DRB Application No.: 04DRB-01380 (FP)
Project Name: SUNDANCE SUBD. UNIT 2
Agent: Isaacson & Arfman PA

Project Number: 1002511
Application Number: 04DRB-01380

**CITY OF ALBUQUERQUE
PLANNING DEPARTMENT
9/22/04 DRB
Comments**

RE: Tract A, Sundance Subdivision, Unit 2/final plat

**PLAT**  
FOR  
**SUNDANCE SUBDIVISION**  
**UNIT 2**

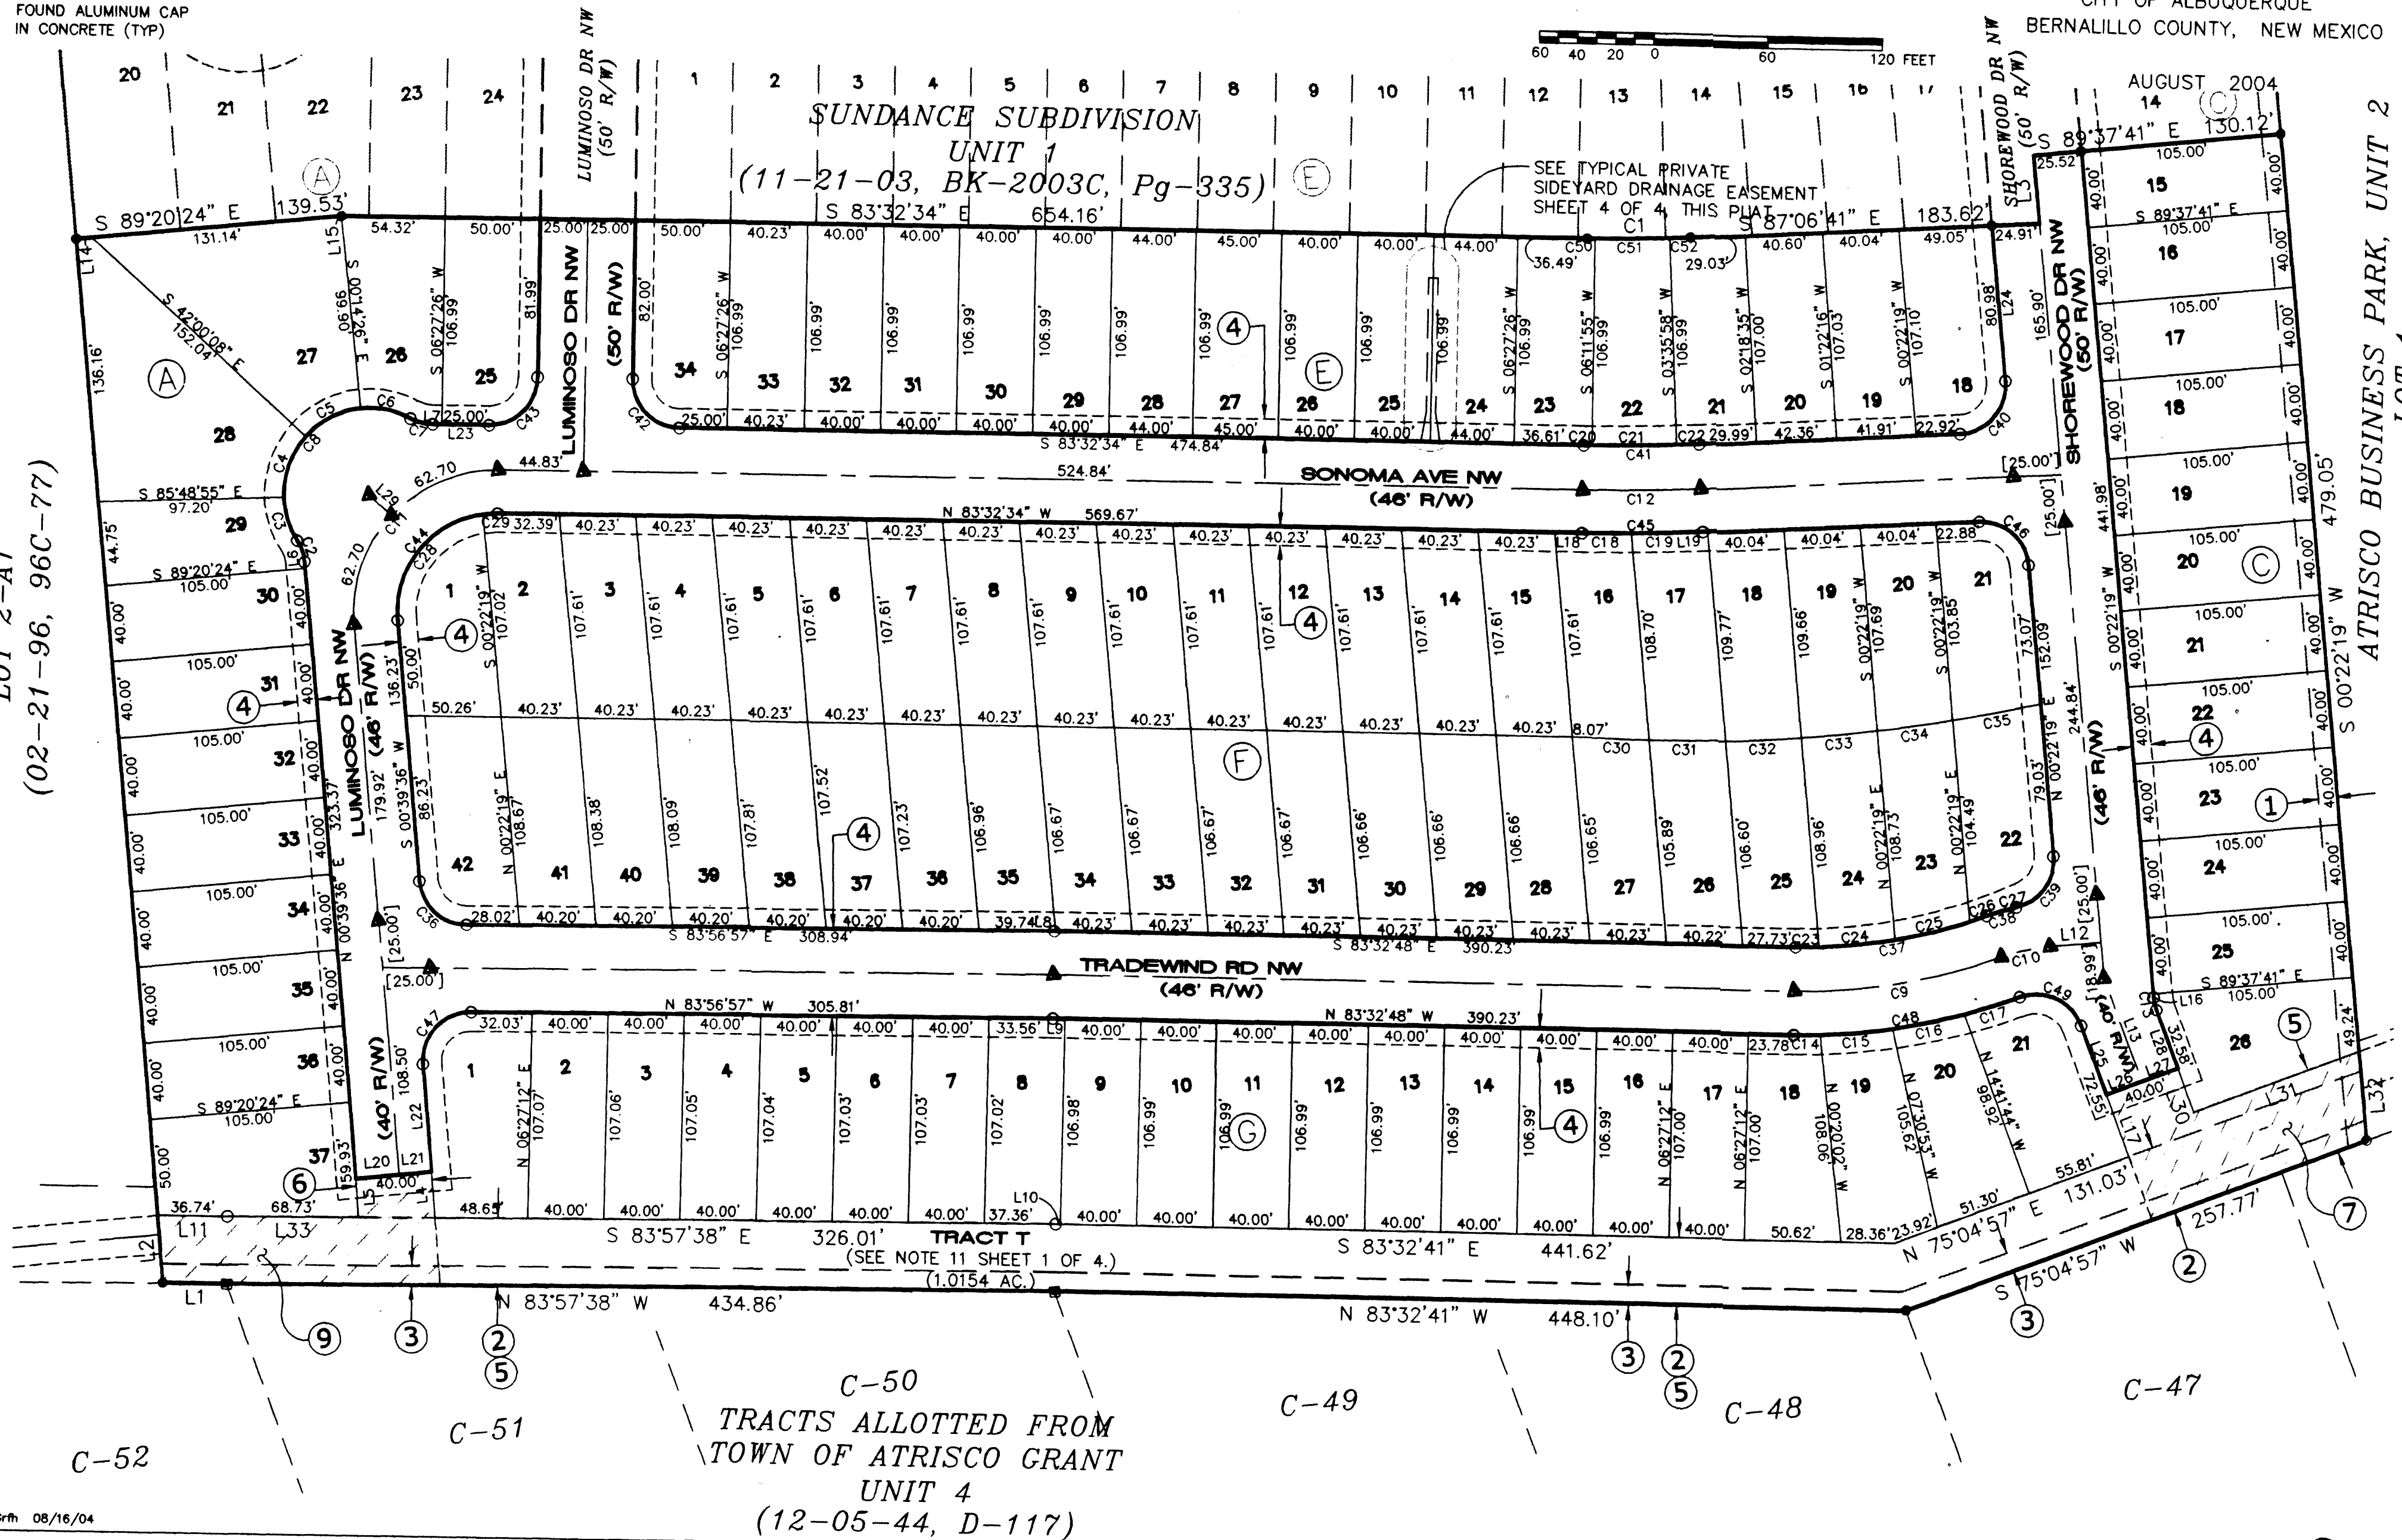
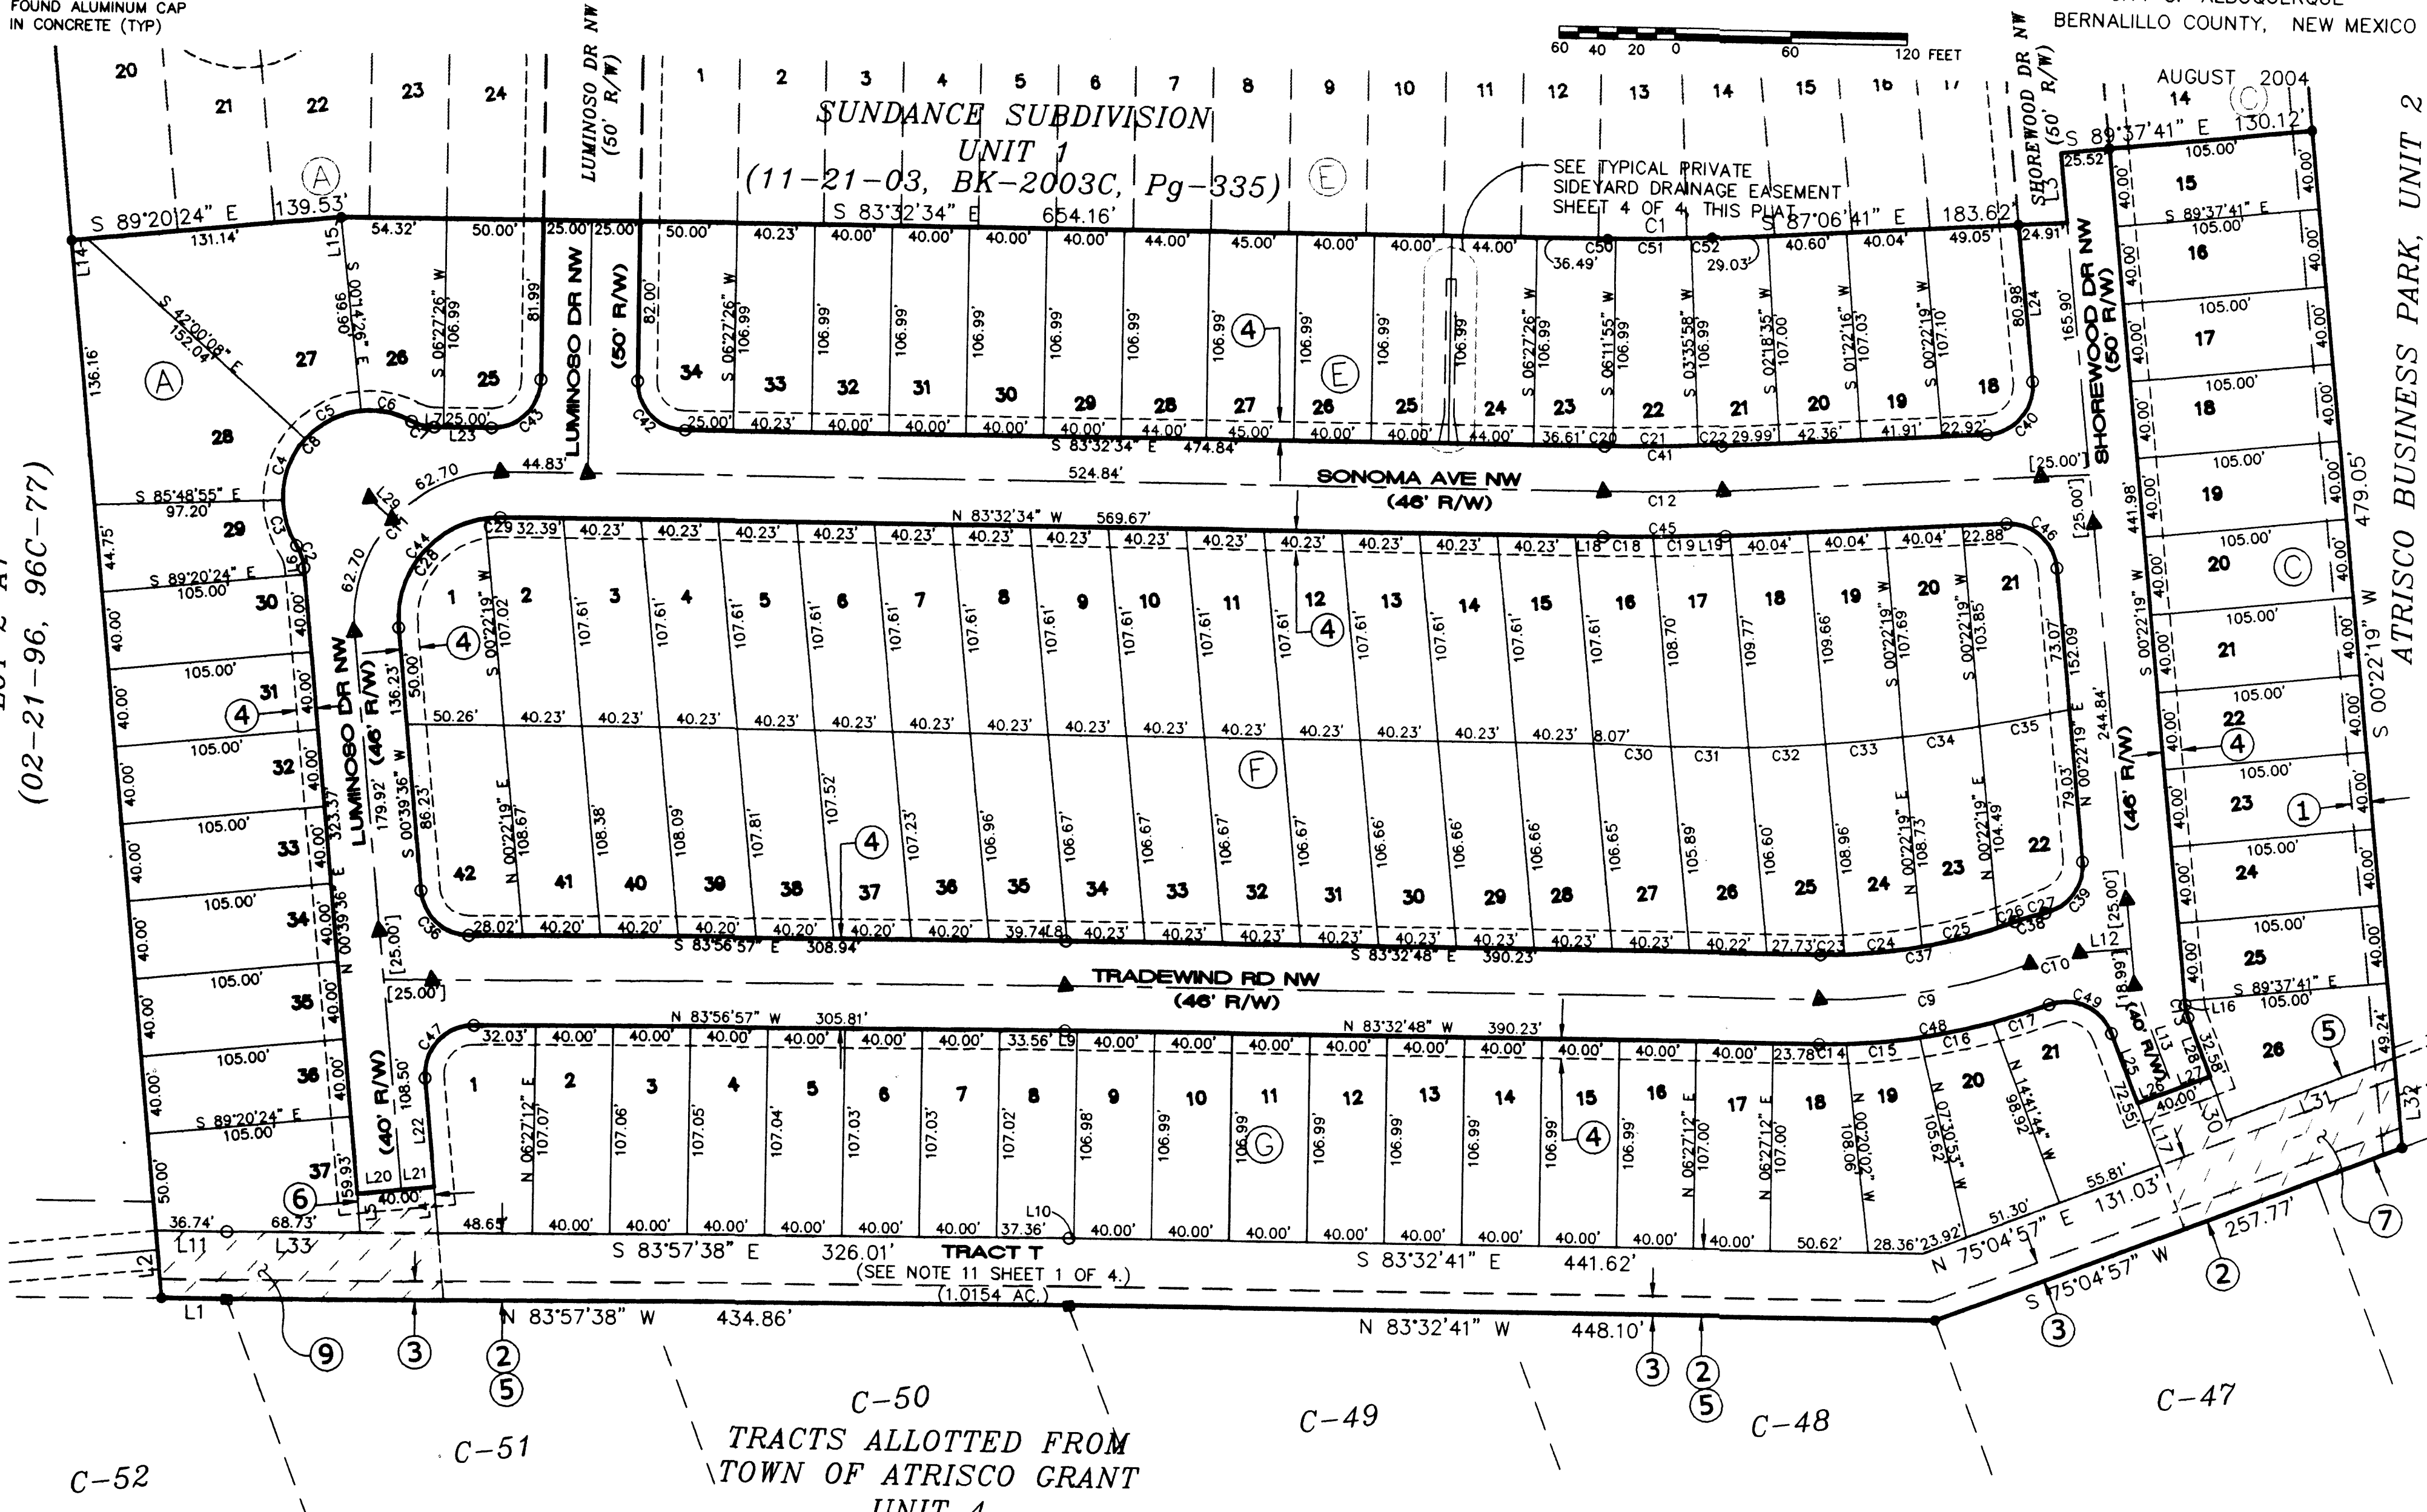
Are there any changes between the preliminary plat approval and this final plat submittal?

No objection to final plat approval provided there are minor if any changes from the approved preliminary plat .

The current zoning should be on the final plat.
